The Able Marine Energy Park Development Consent Order

Planning Inspectorate Reference: TR030001

**Written summary of the oral representations of C.GEN Killingholme Limited at the
Issue Specific Hearing on the draft Development Consent Order**

23 July 2012

Drawing file: published-documents / TR030001-003455-Able NMC - Tab 3(1) - Substitute Plan - AME - 02006 C Indicative Masterplan.pdf

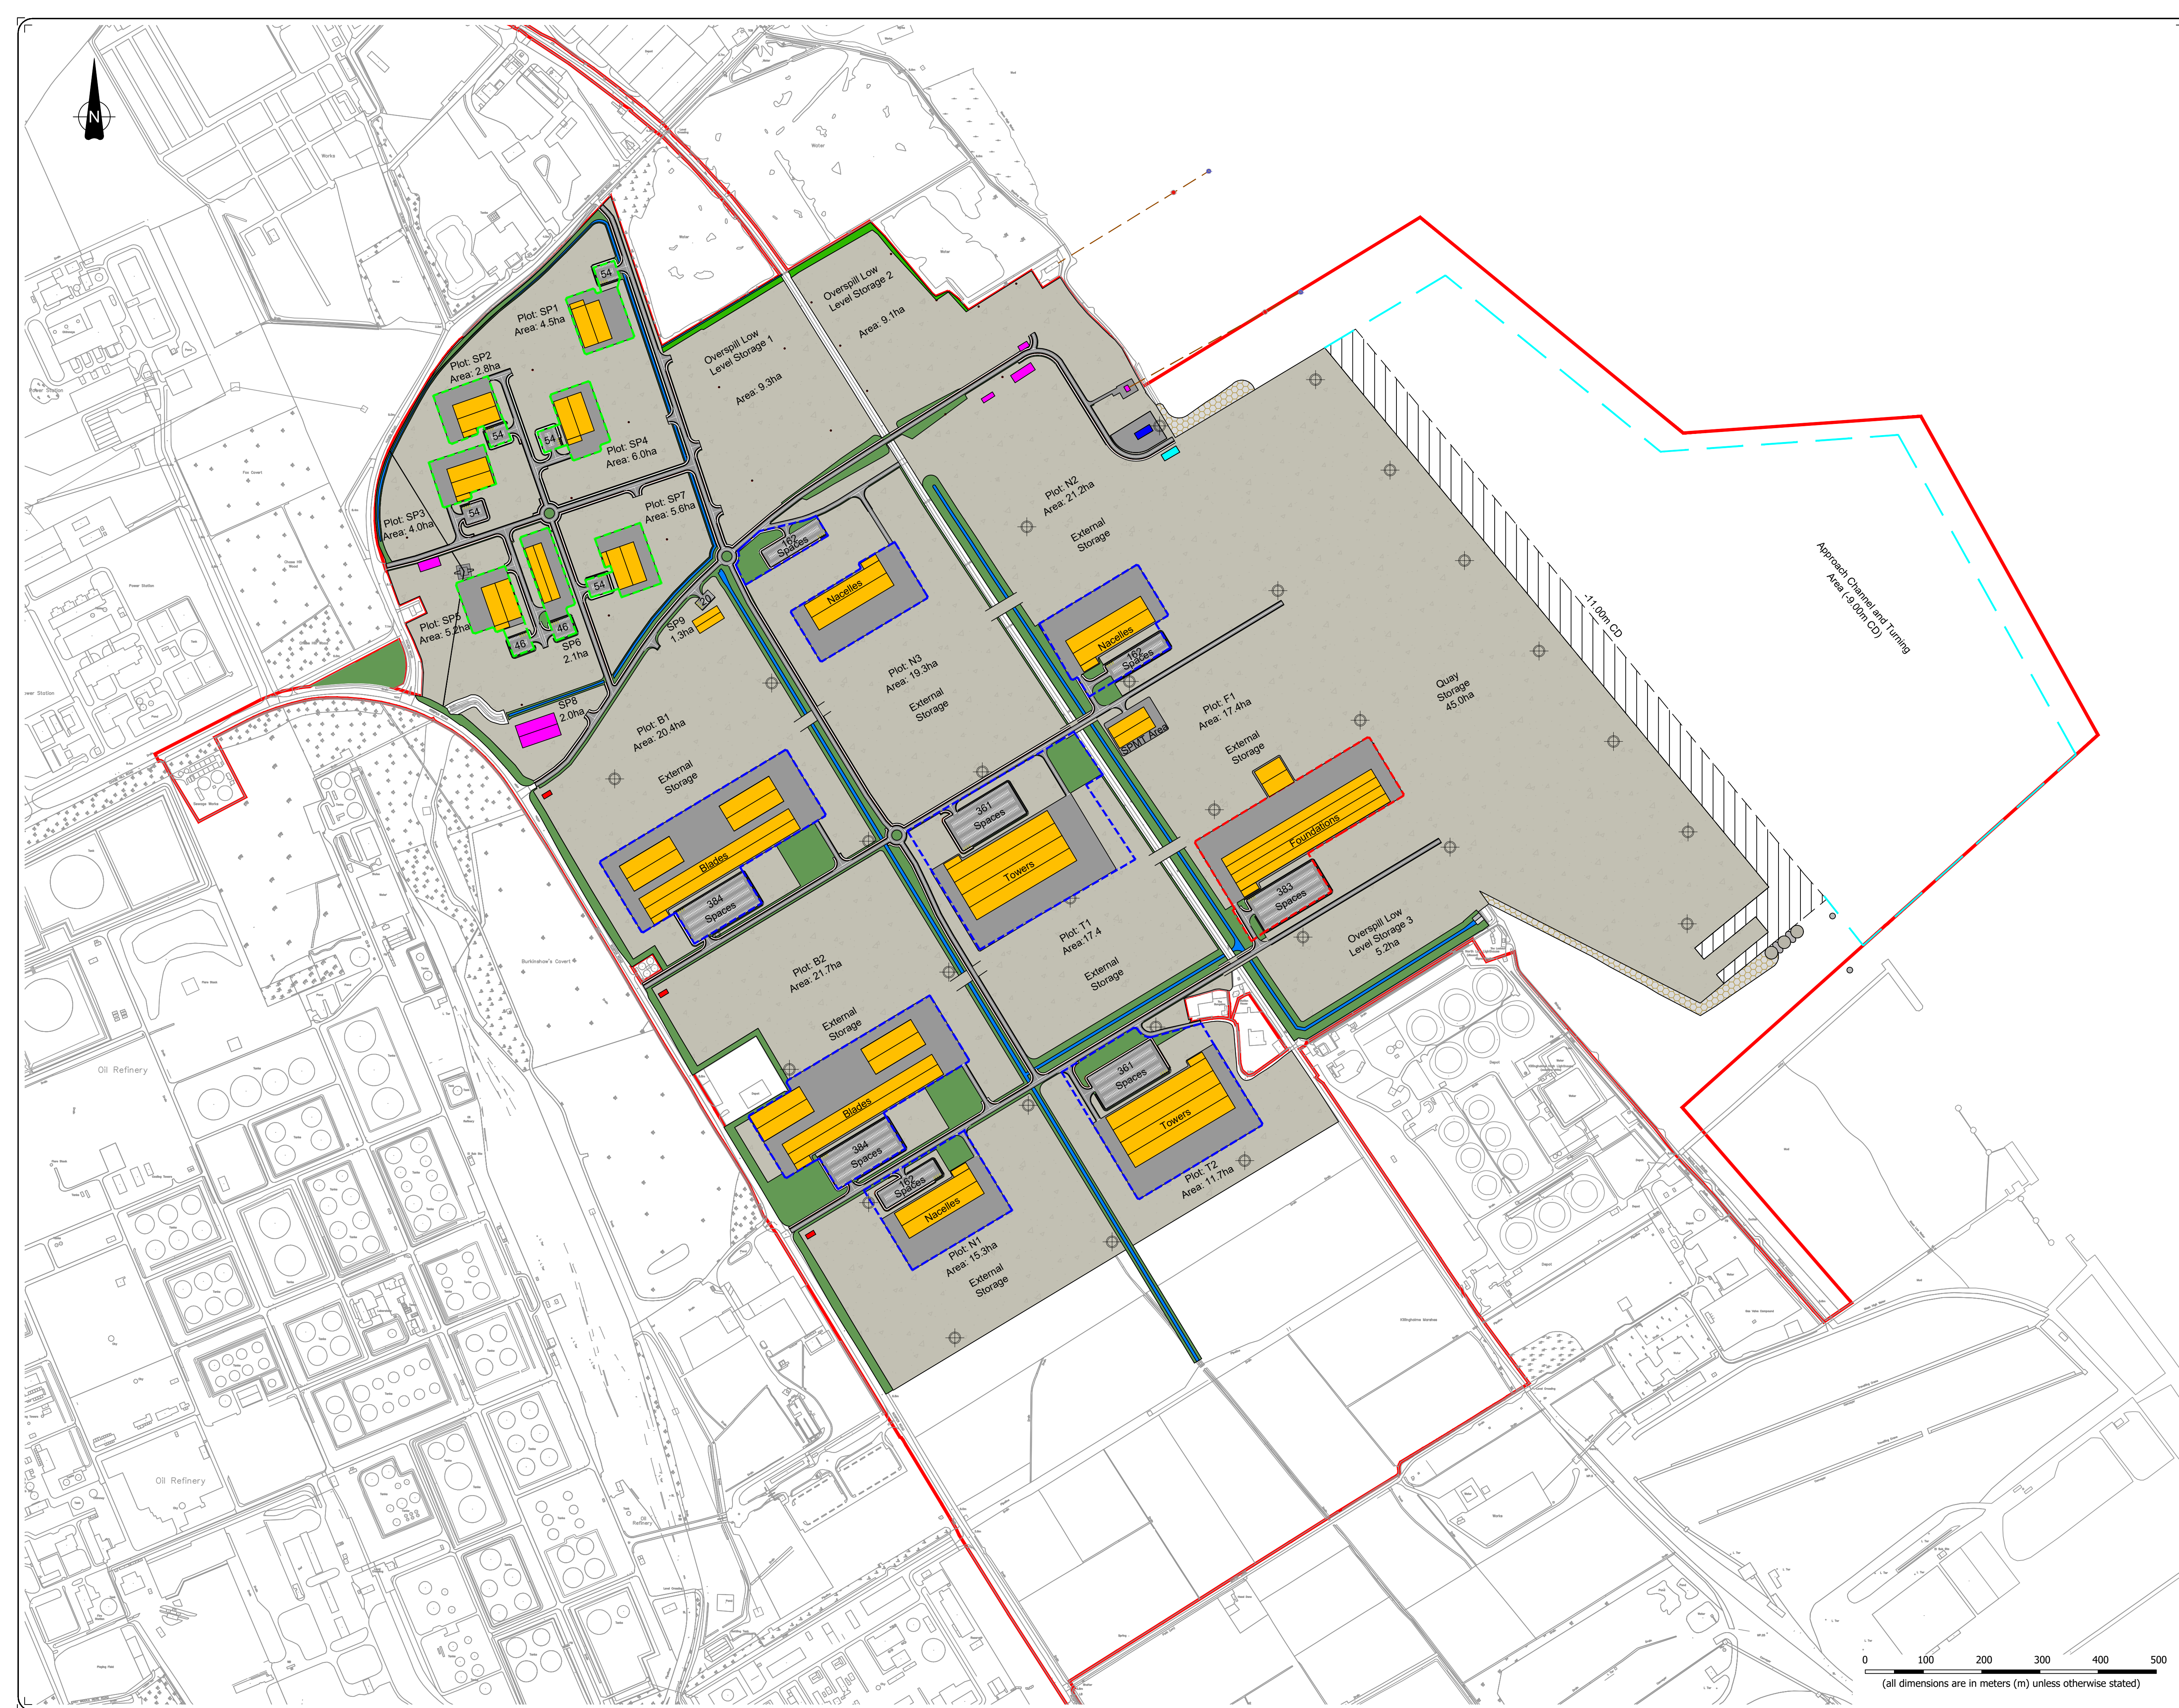
4. The design of AMEP is currently addressed in design drawings, which are for Work No. 1 only, and in a collection of drawings marked "planning application drawings" that do not appear to be referred to anywhere in the DCO or the requirements attached to it. Those planning application drawings include drawings that are confusingly labelled "indicative".

This includes an Indicative Masterplan drawing, the purpose of which is unclear. Notwithstanding its name, it appears to show a layout for the landside elements of AMEP, including three level crossings. How this will be delivered or secured - if at all - is not certain.
